Application for a non-material amendment following a grant of planning permission.

PROPOSED GARAGES & BOAT SHED.
H-18-0654-10

H 18 - 0654 - 10

Proposed Boatshed and Garages, Prospect Lodge, Chestnut Terrace, Sutton Bridge, spalding.
Application number H18-0654-10

number
09-TM-10 B

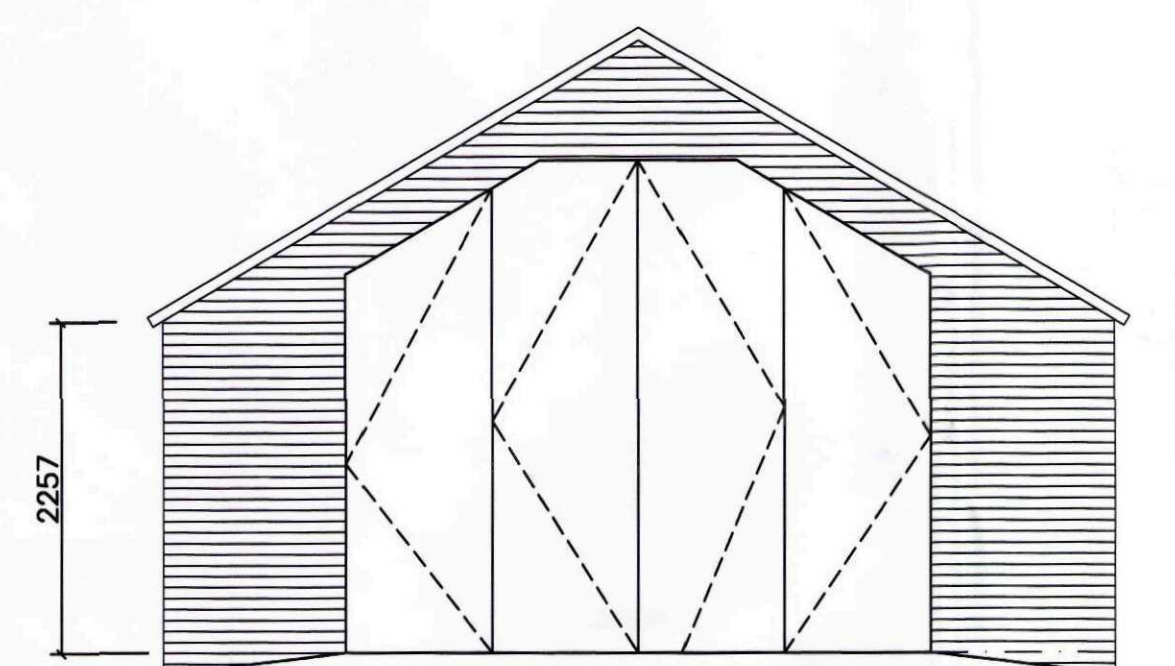
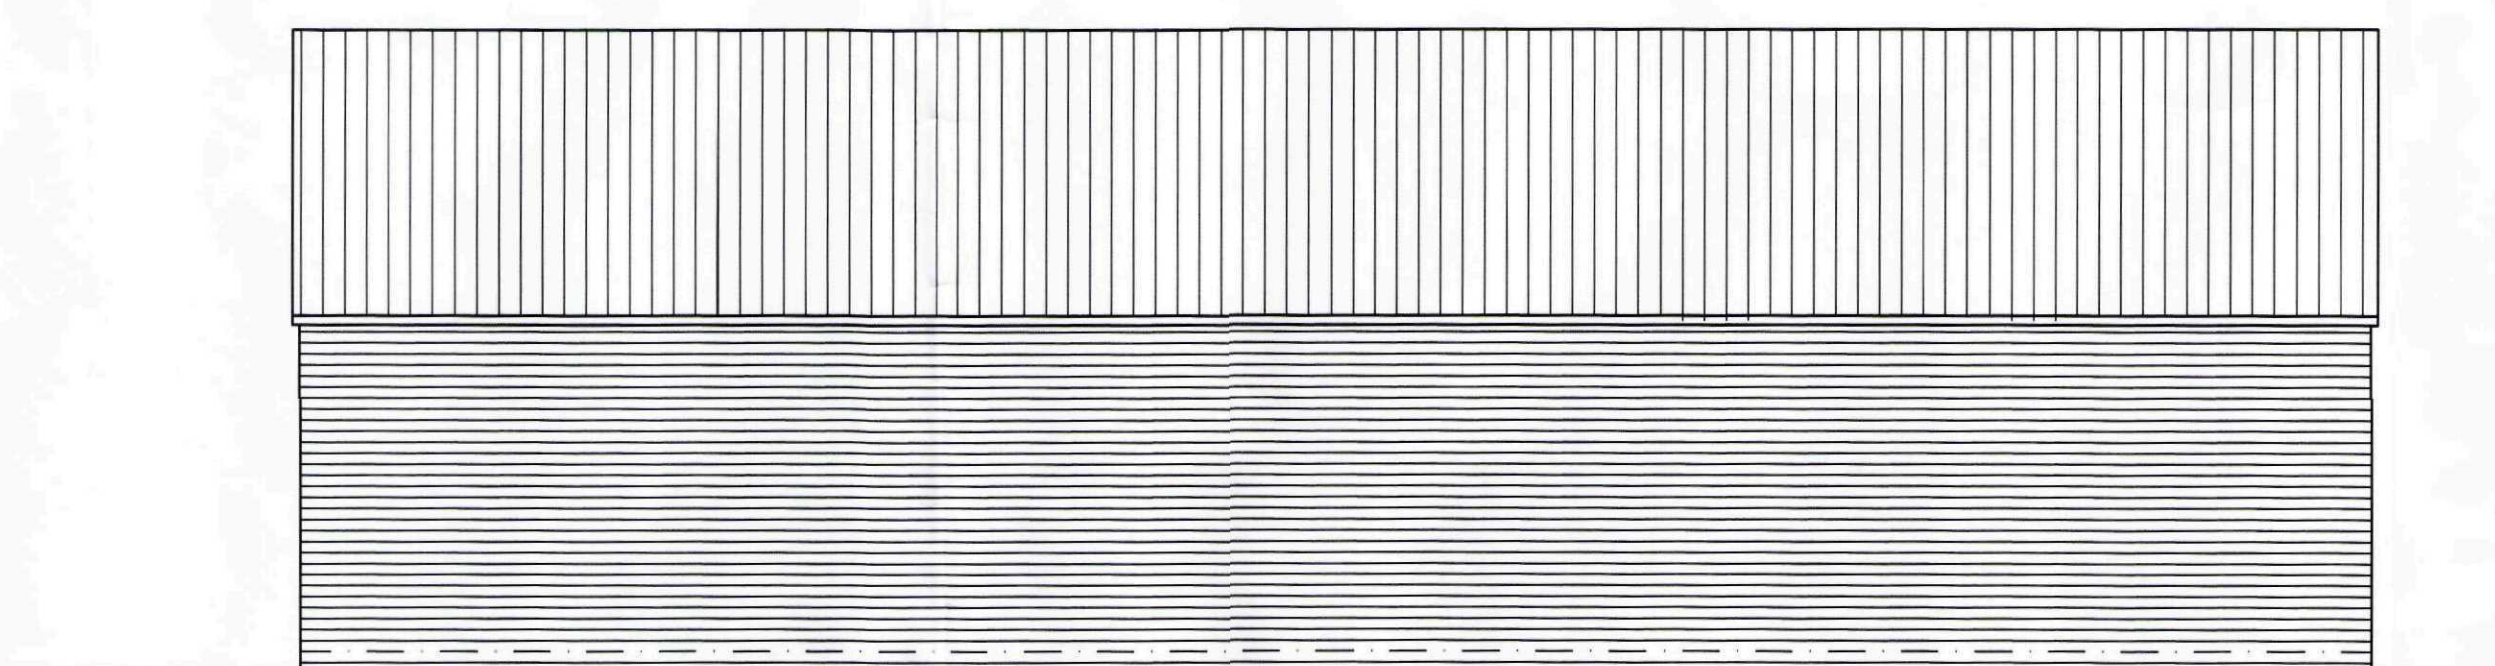
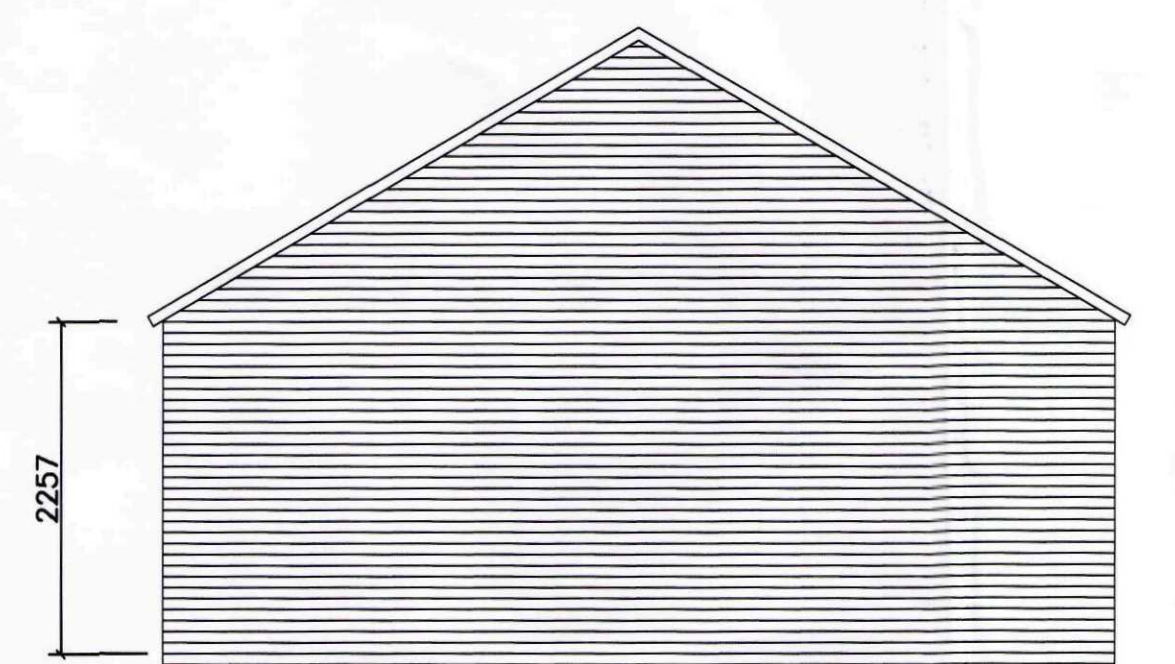
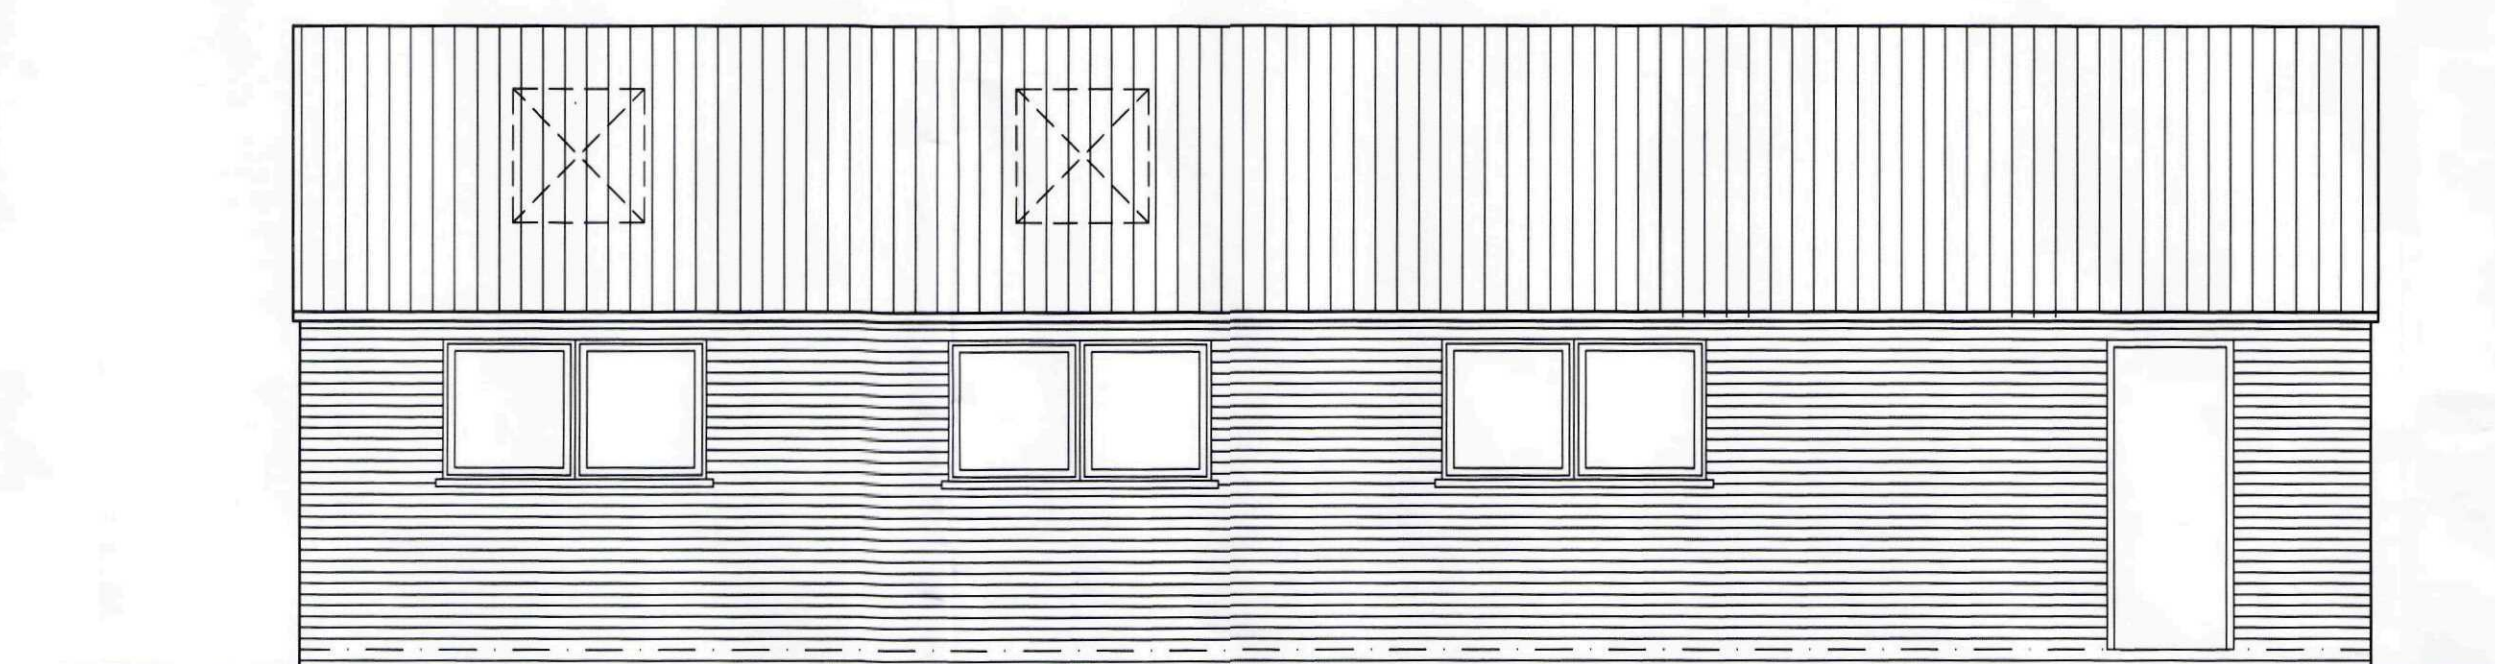
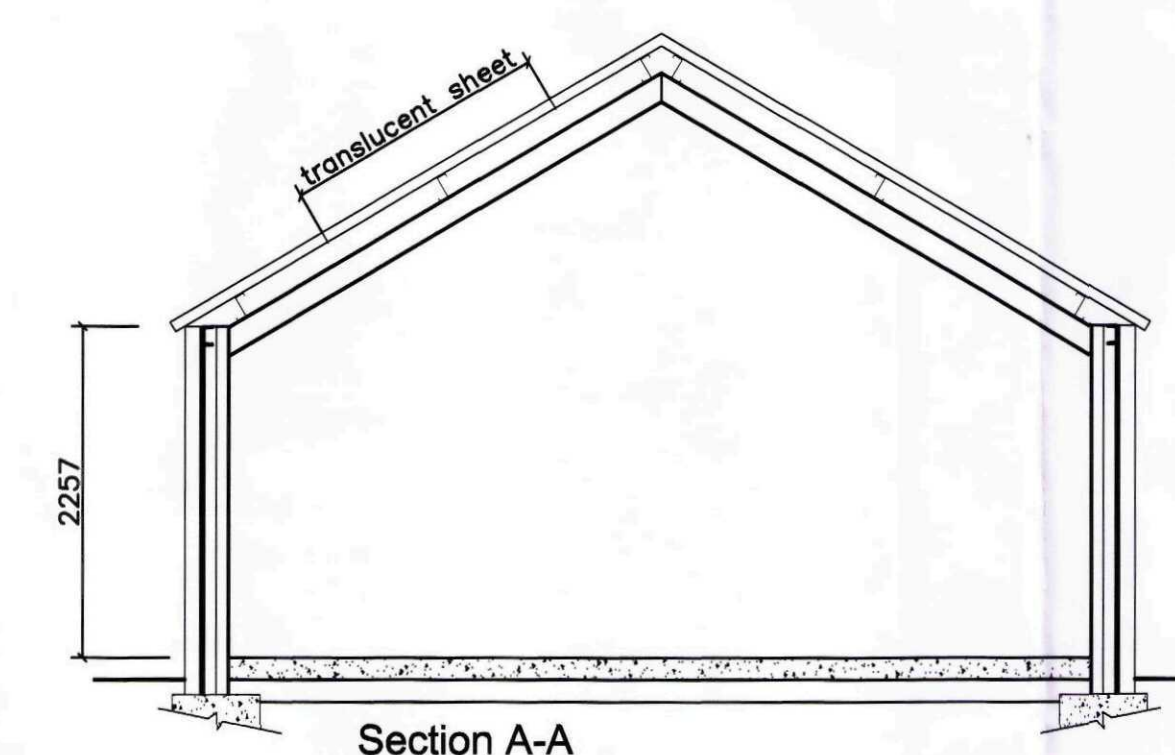
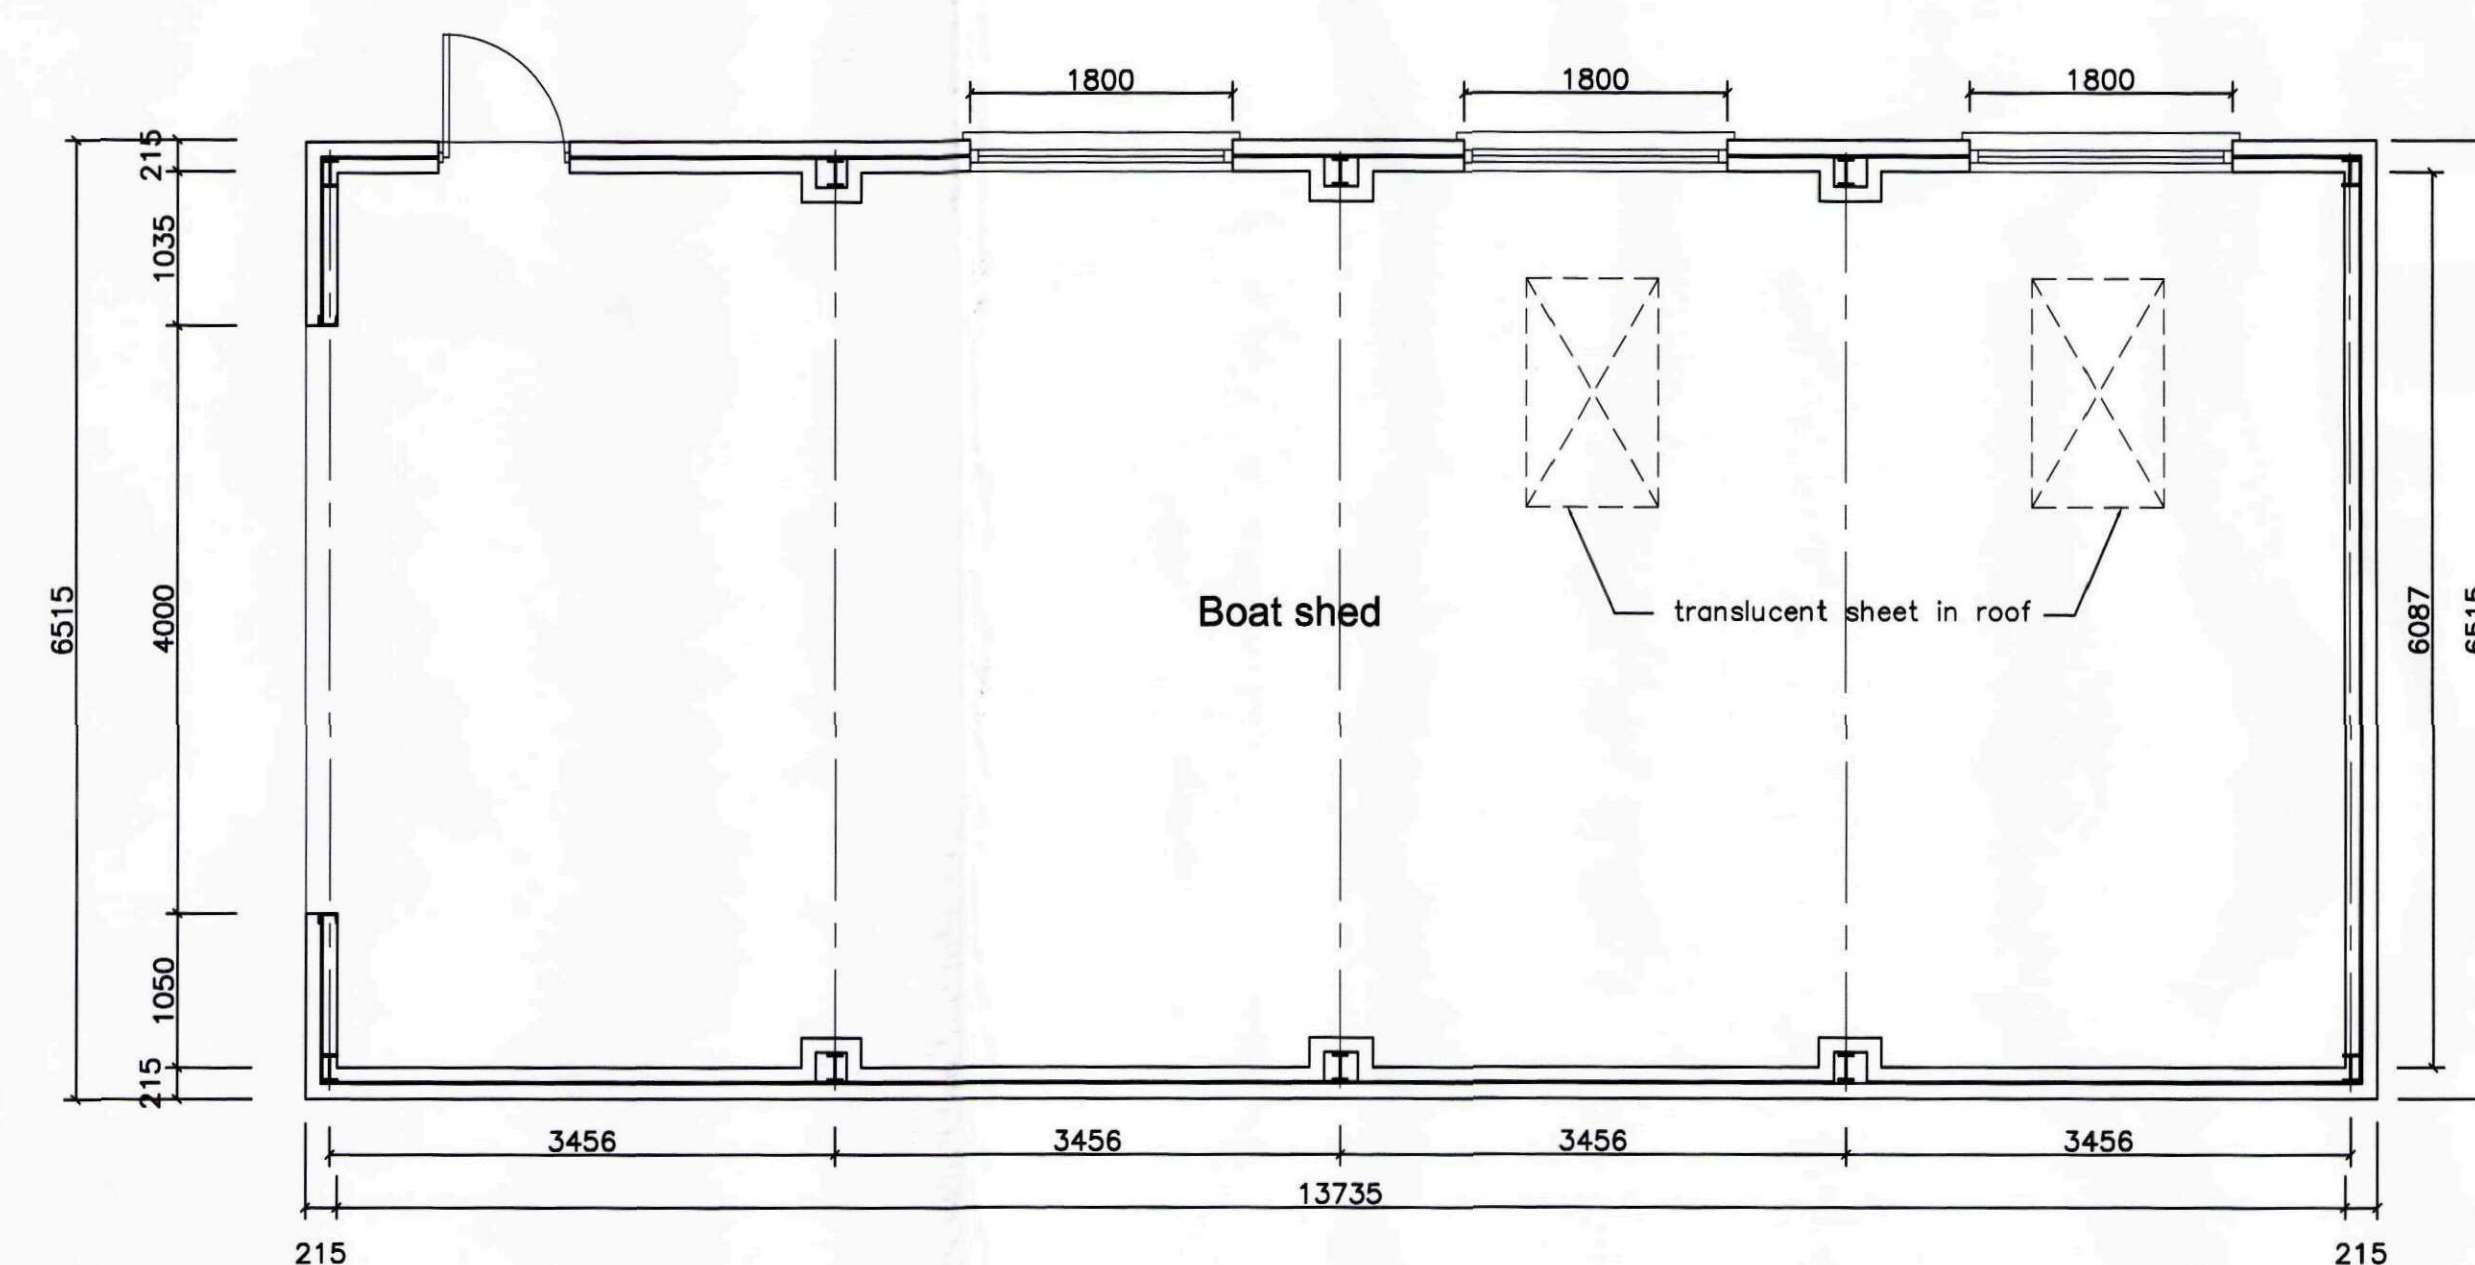
BOAT SHED — ADDITION OF SIDE WINDOWS + DOOR ONTO
CLIENTS GARDEN + 2 NO TRANSLUCENT ROOF PANELS OF
OWNERS SIDE OF ROOF.

09-TM-10B-BOAT SHED
08-TM-10B-GARAGES.
